CONSULTEE RESPONSE (Arun District Council - Arboriculturist)

Reference: AL/30/25/OUT

Proposal: Outline application with some matters reserved (except access) for 2 No. dwellings served from a new access in the location of the existing access. This application is a Departure from the Development Plan.

Location: Land adjacent to 1 Elm Cottage, Hook Lane, Aldingbourne, PO20 3TG

Drawing Title **Site Overview**

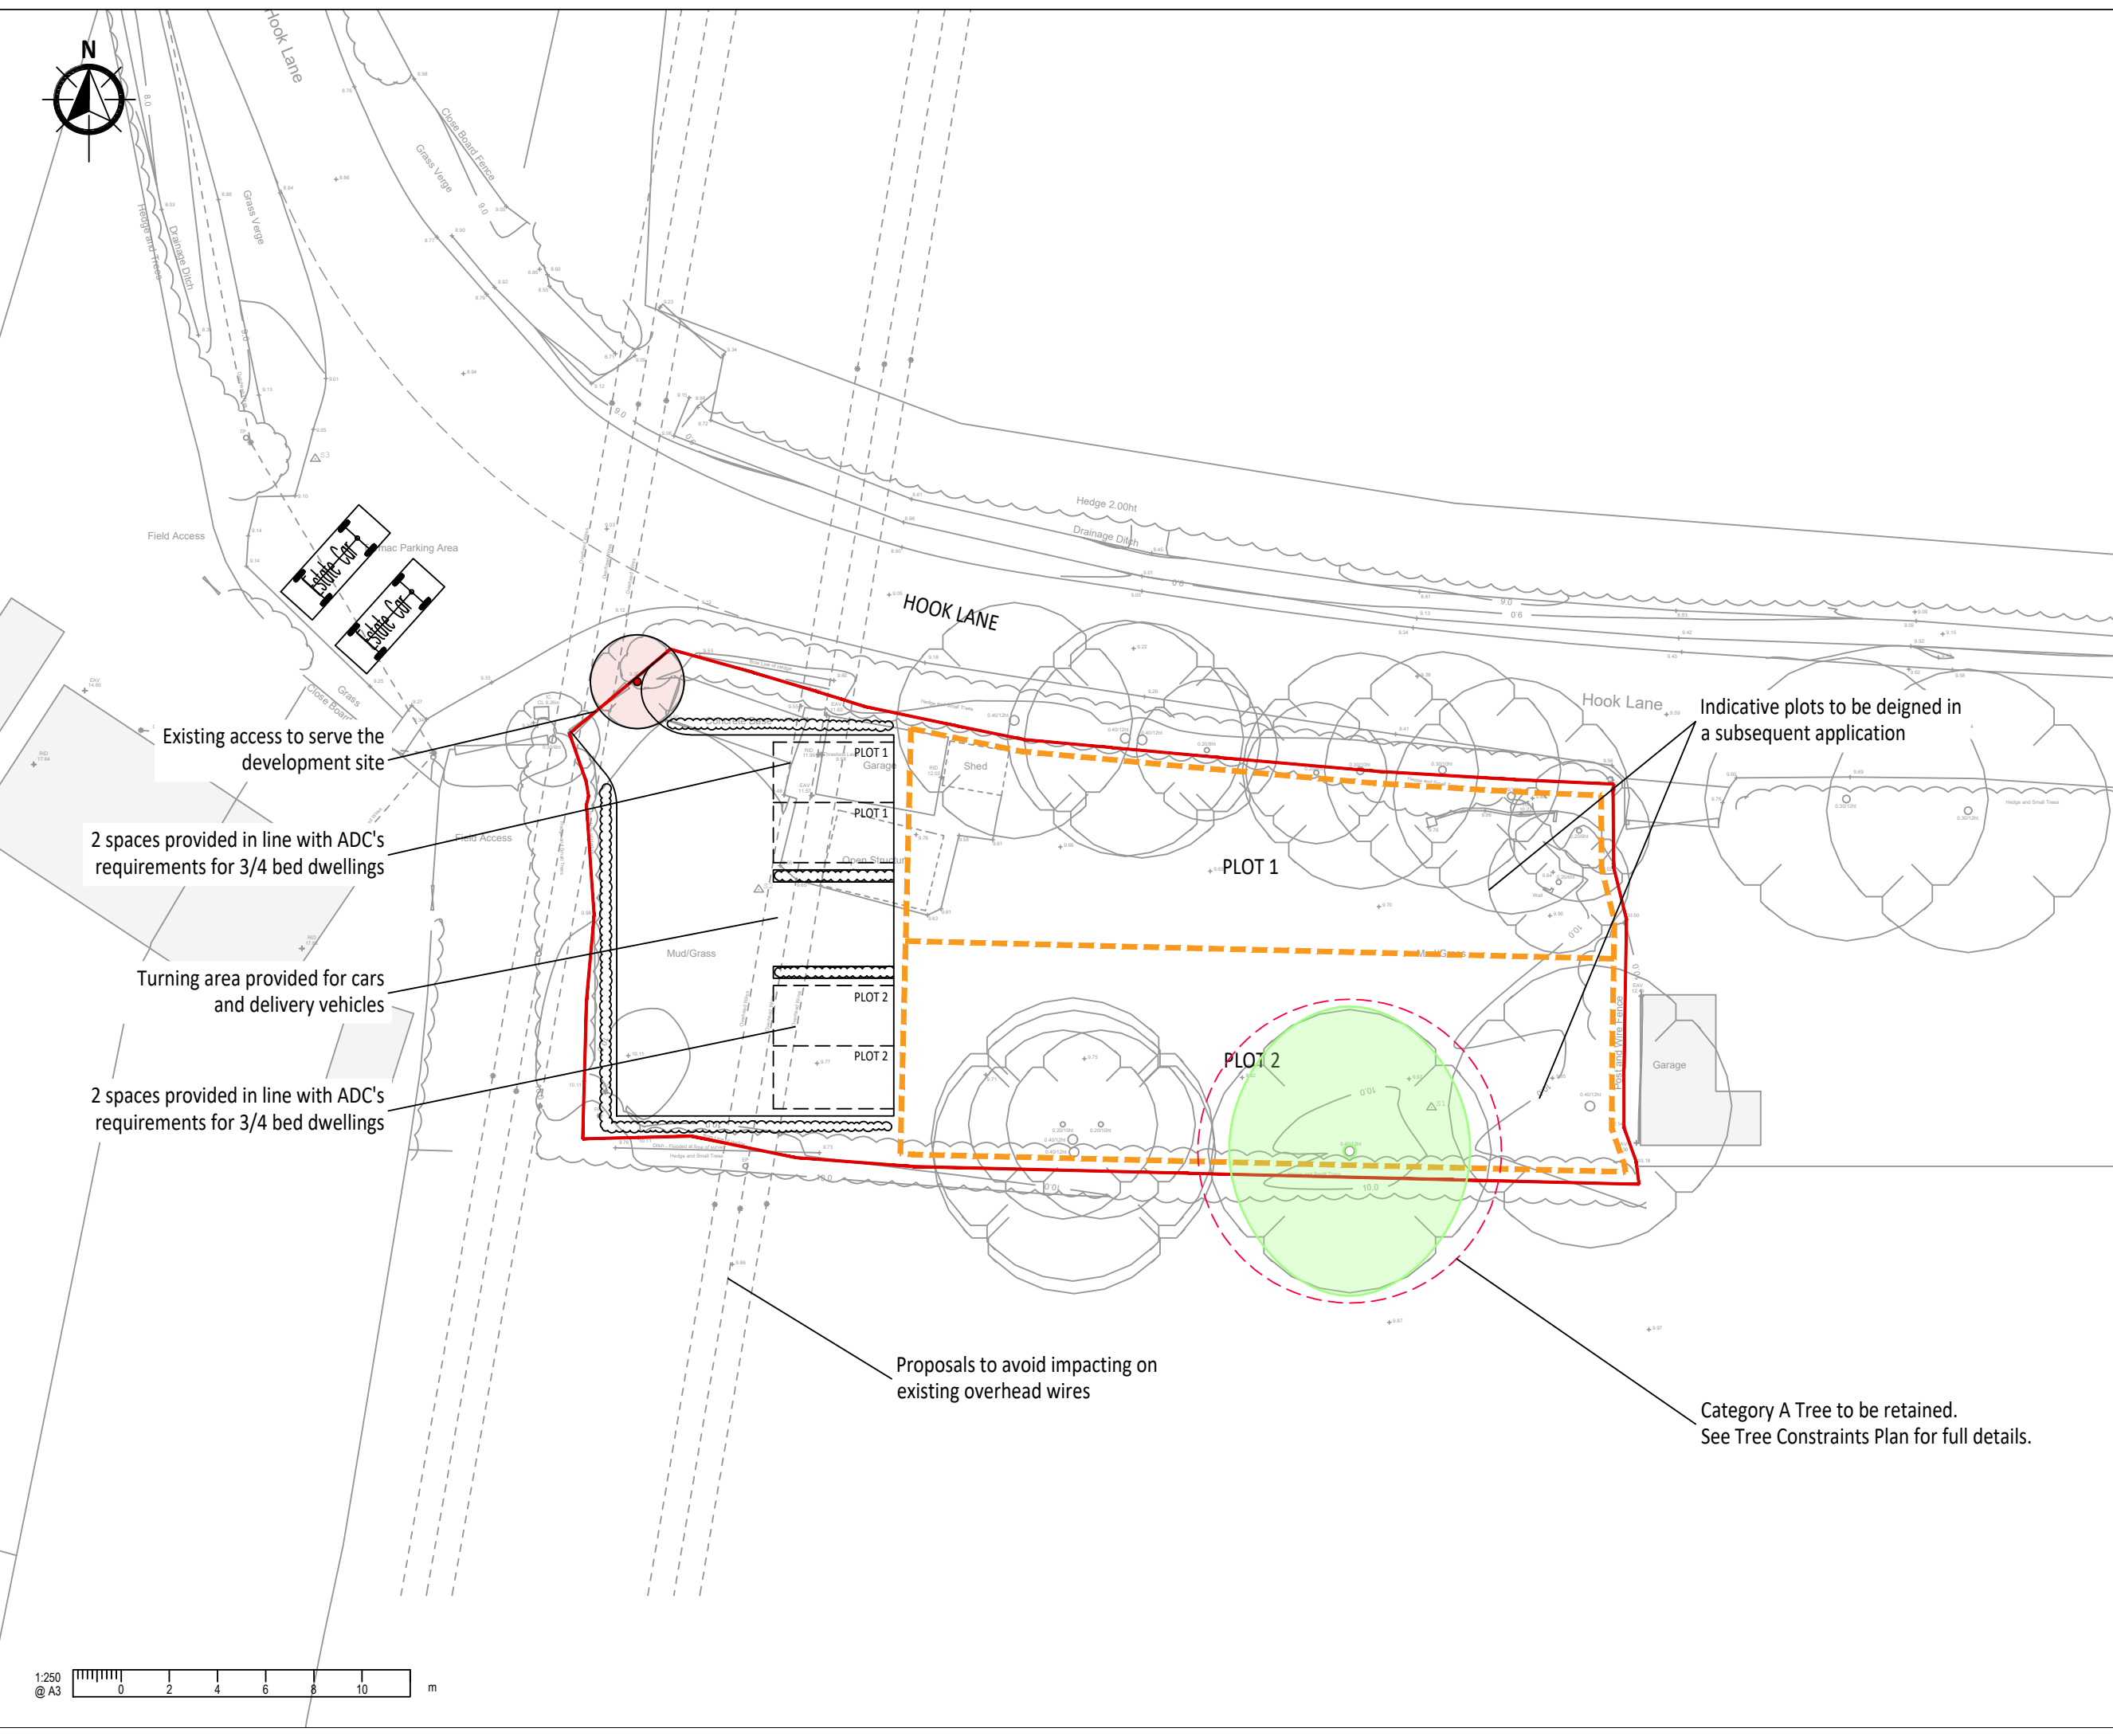
Although we are only considering access and the principle of development, it is also useful at this stage to have a Site Overview (plan dwg. no. 2024-6645-001 Rev B) showing the desired plot configuration. It is clear from the TCP that any development of this site will incur a change of land use over and construction within, the nominal root protection area (RPA) of established trees which ideally should be retained.

Significantly, the desire for two plots would inevitably bring T13 into conflict with the reasonable and expected use of any dwelling and its garden. Aside from heavy shade being cast and high volumes of material being deposited (catkins, leaves, acorns), soft landscaping, lawn treatments and certain permitted development all have potential to cause harm to a tree's ongoing health and vitality. For it to flourish post-development and be tolerable by adjacent household(s) at full maturity, it must be afforded substantially more room than the RPA. The RPA is a layout design tool, calculated from a tree's current dimensions and identifies the minimum area of ground left undisturbed to maintain the tree's viability. It does not take into account future root and crown spread.

Tree Constraints Plan

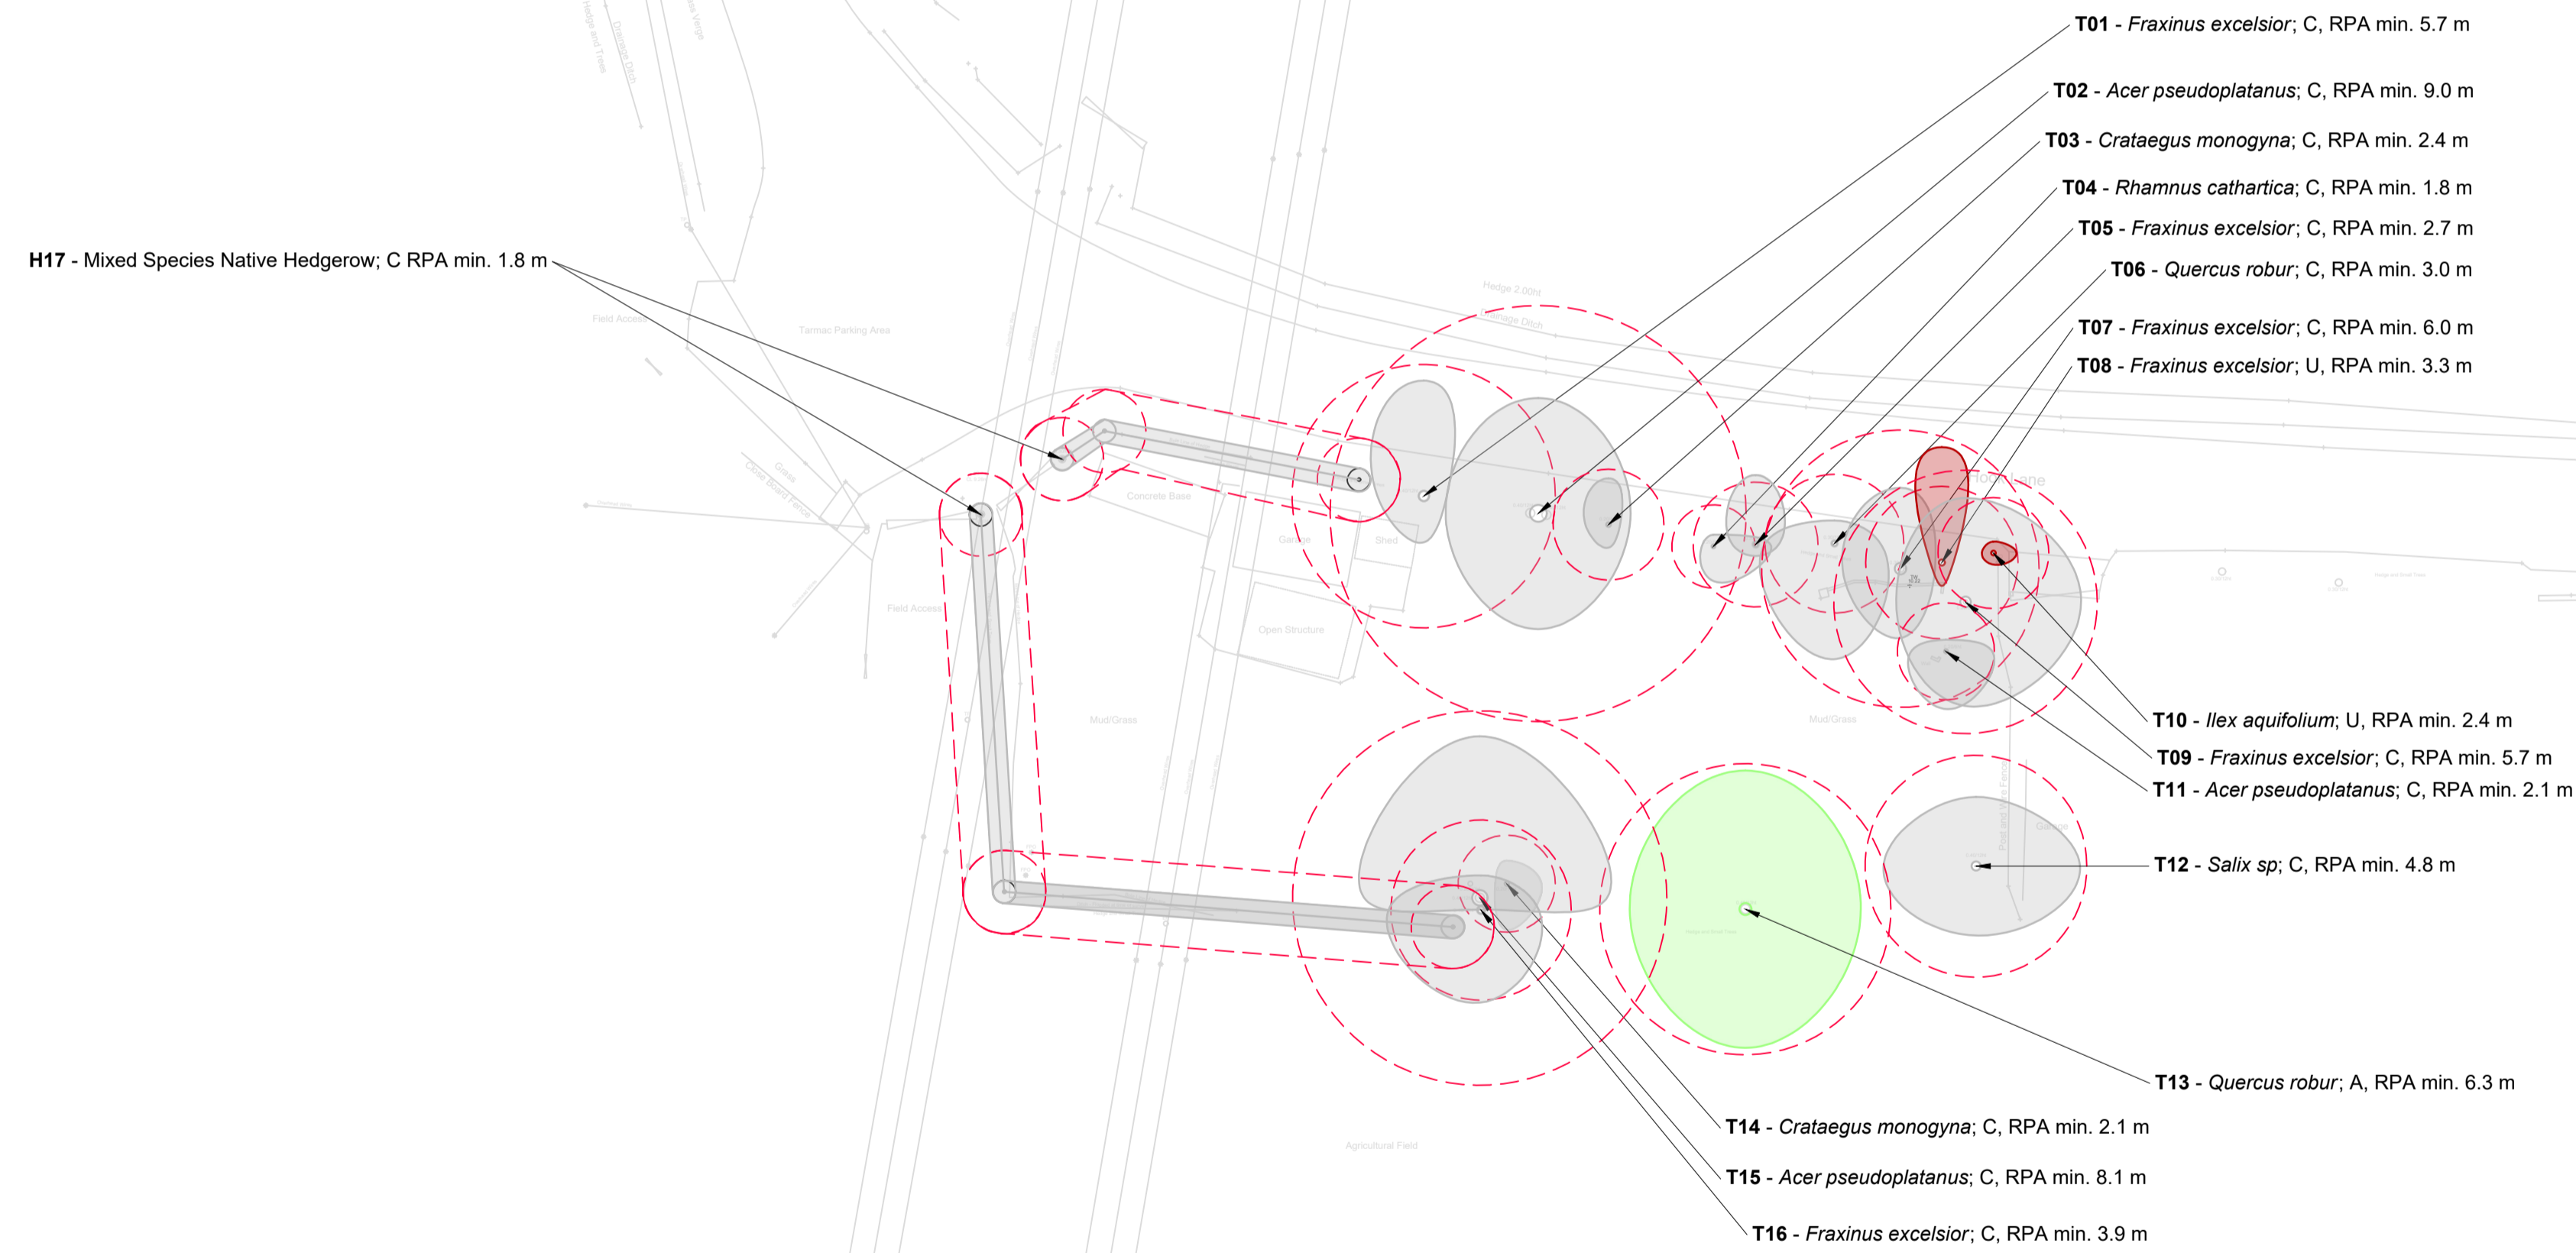
The applicants have employed Lizard Landscape & Design Ltd. to prepare a Tree Survey Schedule and Tree Constraints Plan (TCP) for this project. The Tree Survey data is comprehensive and accords with the requirements of BS5837:2012. I agree with the retention category ratings.

Site boundary trees make an important contribution to the landscape and rural character of the lane. Those growing roadside are typically of low value in a planning context but nonetheless provide useful screening and have ecological value. The obvious one of high quality is an oak on the southern boundary (T13), a category A tree with considerable growth potential. It is recommended this tree be made the subject of a preservation order to both preserve its place in the landscape and influence any future layout proposal.

T13 is visible from the public highway and will be increasingly so as it matures. Furthermore, it may remain the only tree of landscape value in the foreseeable future, as loss of ash and maintenance of poorly structured sycamore on the north boundary, would increase the view of its canopy.
